RE: GRADING & DRAINAGE PLAN FOR TUAN OFFICE BUILDING (J-19/D073)
ENGINEERS STAMP DATED 5/9/00 SUBMITTED FOR BUILDING PERMIT
and SO 19 APPROVALS

SUBJECT: TUAN OFFICE BUILDING (J-19/D073)

SUBJECT: Tuan Office Building, Pennsylvania & I-40, SE Quadrant

GRADING & DRAINAGE PLAN

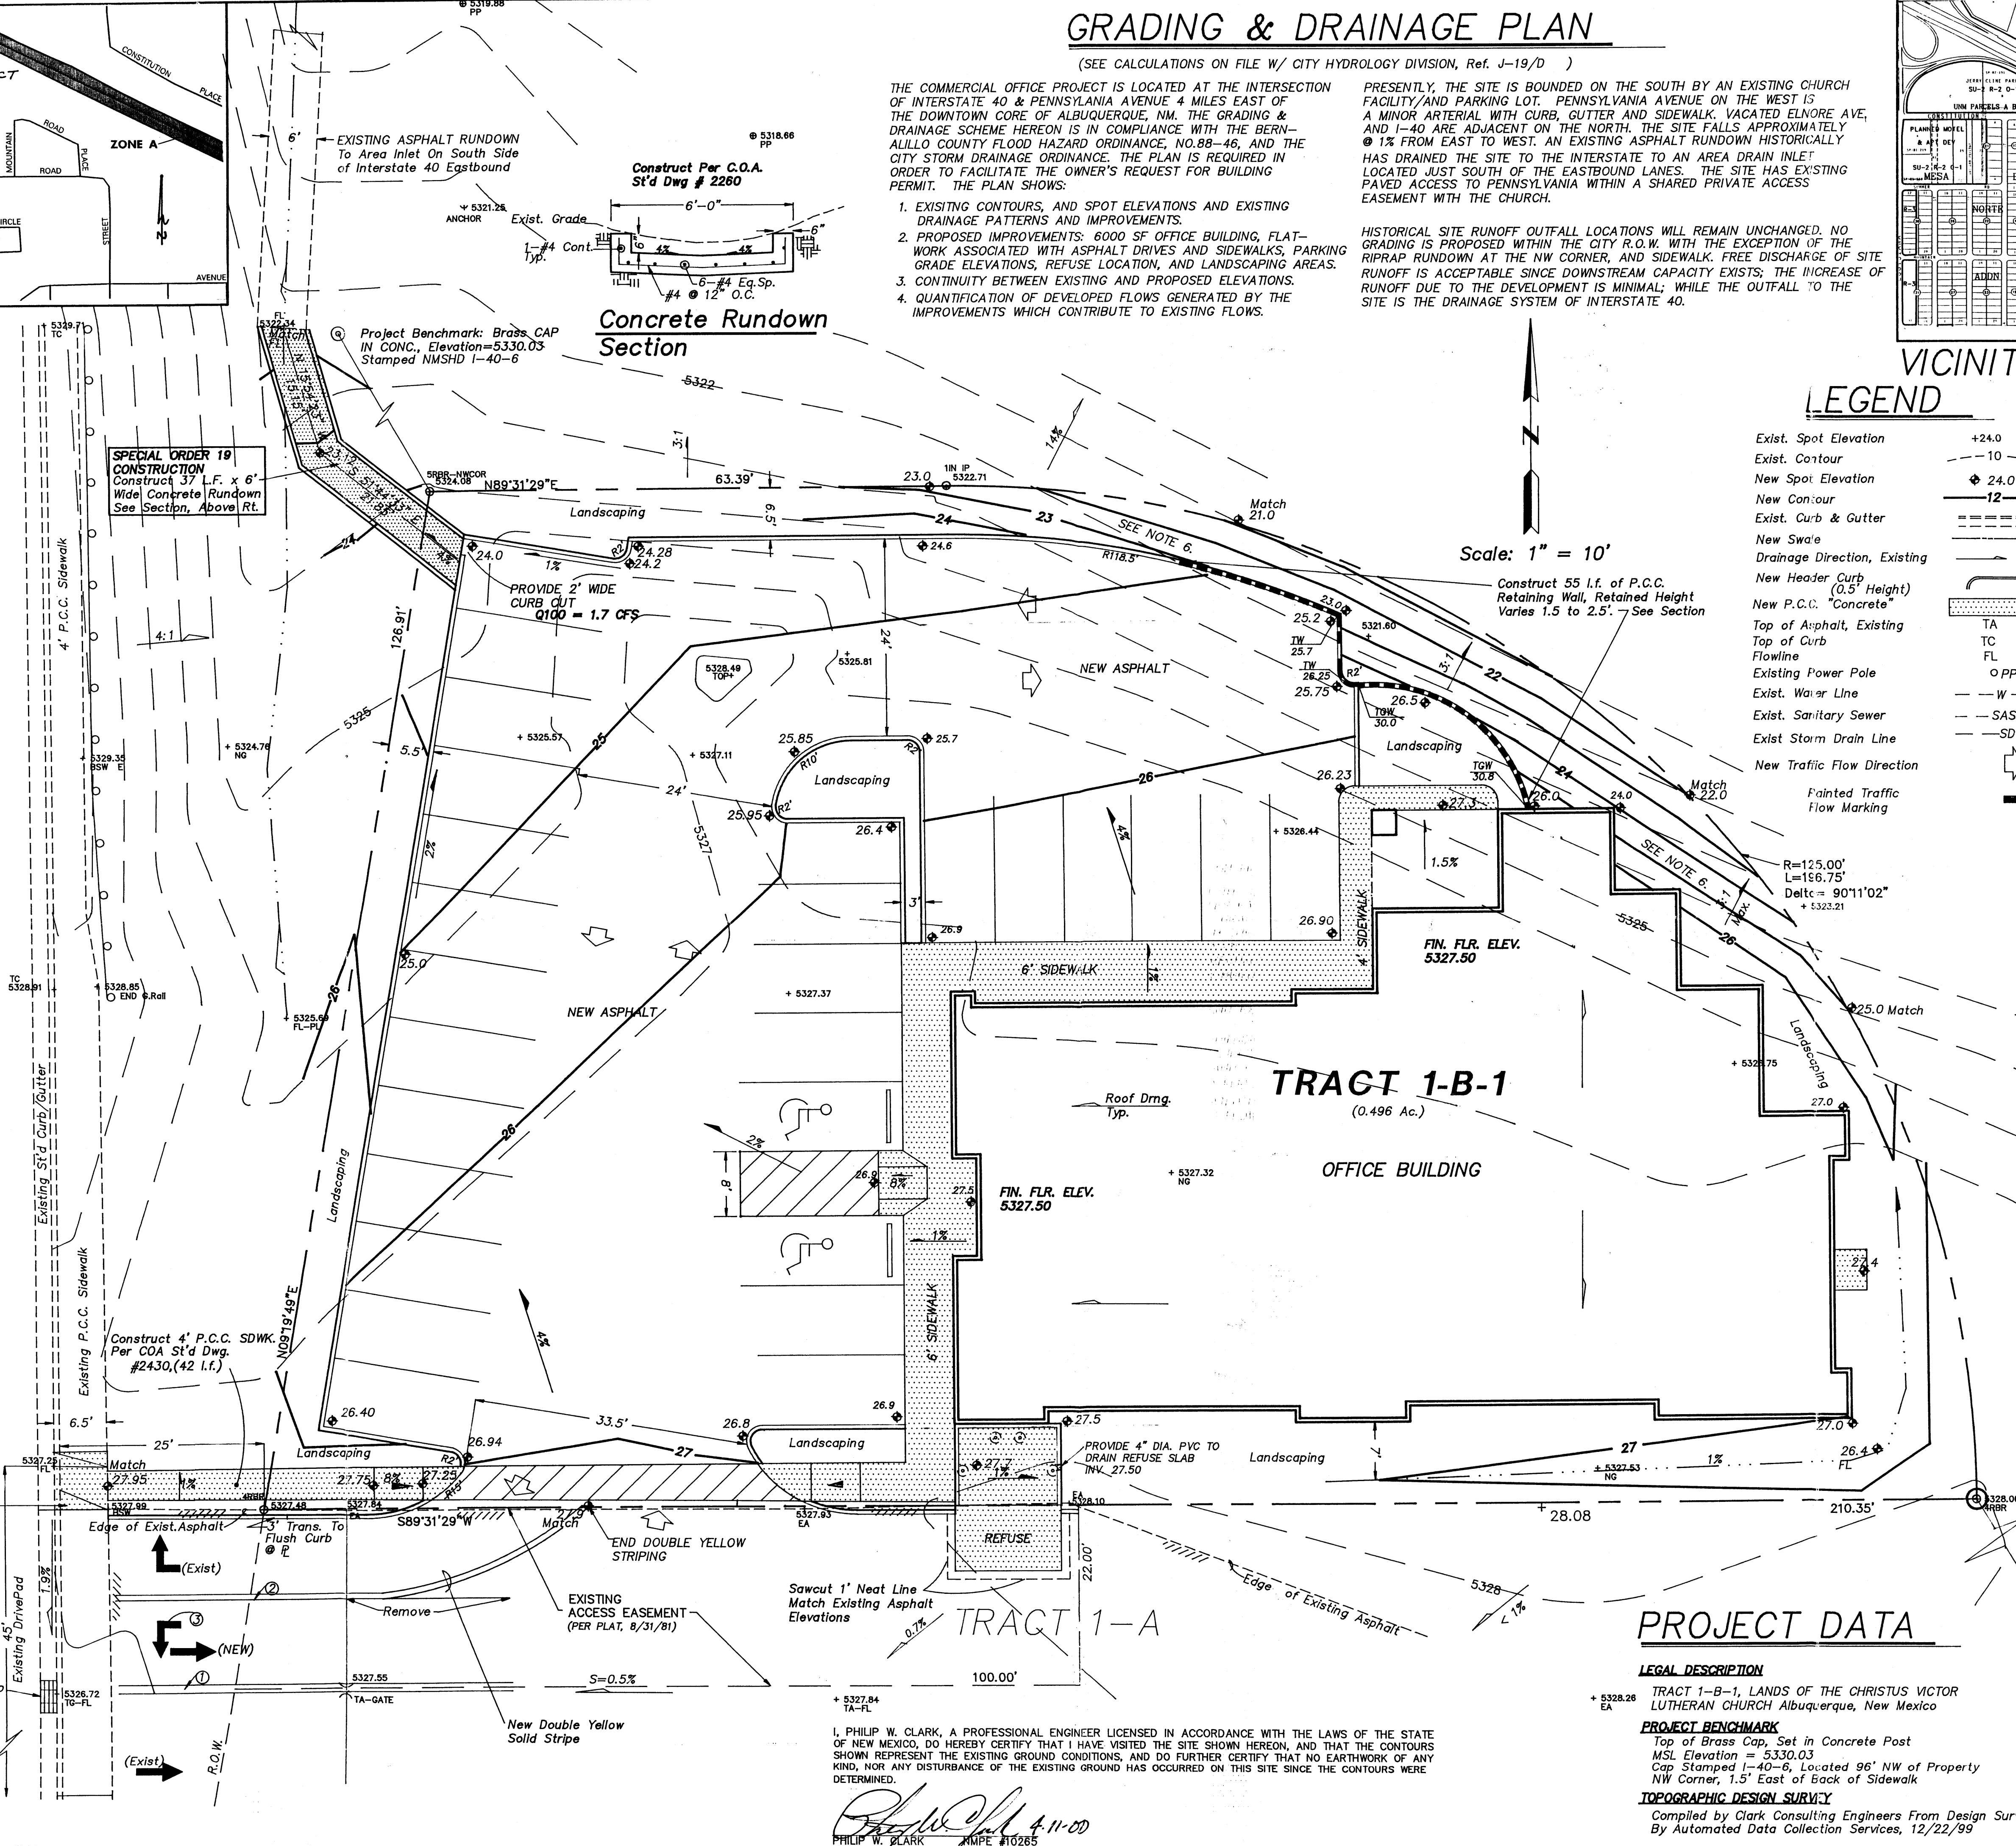
1. Off-site flows - you state that no off-site flows enter the property from the church parking lot to your south. Your contour lines, however, show a 5328' line in the adjacent property and a 5327' proposed contour line defining the swale along the south side of your site. How is it possible that the run-off will not move downhill? Please show enough contours on the adjacent lot to demonstrate that your site receives no off-site flows.

2. You propose to cut the asphalt and install a concrete pad for a refuse container on the adjacent property. While there does exist an access easement across that property, I am uncertain that it gives you the right to build or repave without the owner's permission. Please get written agreement from the property owner to the south for the proposed refuse site.

3. Please quantify the run-off leaving the site via the 6' wide rip-rap swale, and calculate capacity of the swale to demonstrate that the 100 year storm run-off will stay within the swale as designed.

1. Added flow arrow and spot elevation along the south boundary that should clarify your concern at the southeast area of the plan. These off-site flows exit (although slowly due to flatness of the existing slope) to the west through the existing drivepad.
2. Please see attached memo from Mark Vreeland.
3. I'm not sure if the following calcs were included in the original file. I've added the capacity analysis of the rock swale.

- ✓ Capacity of 6' Wide Top Swale - 'V' shape
n = 0.045 6:1 sideslopes @ S = 4%
per Mannings Eq.

Q = 3.9 cfs
cap.

>> 1.7 cfs OK
where: $d_{100} = 0.37'$

1. The property is bordered on the north and east by a vacated parcel. Please furnish us with the vacation ordinance to assure us that there are no existing easements which will be affected by your proposed construction.
2. Please establish that the rundown at the northwest corner of the site is within COA right-of-way. If it is within the Highway Department right-of-way, you will need their permission to construct your drainage structure.
3. If the rundown is to be built within the COA right-of-way, it can be built under an SO-19, in lieu of a Work Order, but must be constructed with concrete instead of loose rock. Please furnish us with two copies of the grading and drainage plan if you plan to need an SO-19.

1. Based on the minimal increase of flow from the historic due to this development, and items 2/3 below, free discharge should be acceptable for this project, since downstream capacity exists.
2. The existing asphalt rundown has the following geometrics:
S=7%, top width is 6', "V" shaped, side slopes of 6:1.....and therefore

Hydraulic characteristics of, Q capacity of 13.6 cfs, @ vel. 9.1 fps @ depth = 0.5'
>>>Q design = 2 cfs.....ok

The rundown extends down to the toe of existing slope where heavy vegetation exists, and no apparent erosion has occurred. The area inlet is similar to the following Type 'D' inlet, and has the capacity to accept the site flows. A twenty-four inch diameter RCP connects to the concrete diversion channel located between the east and westbound lanes. Sufficient 'V' depths exist within this 6' deep inlet.
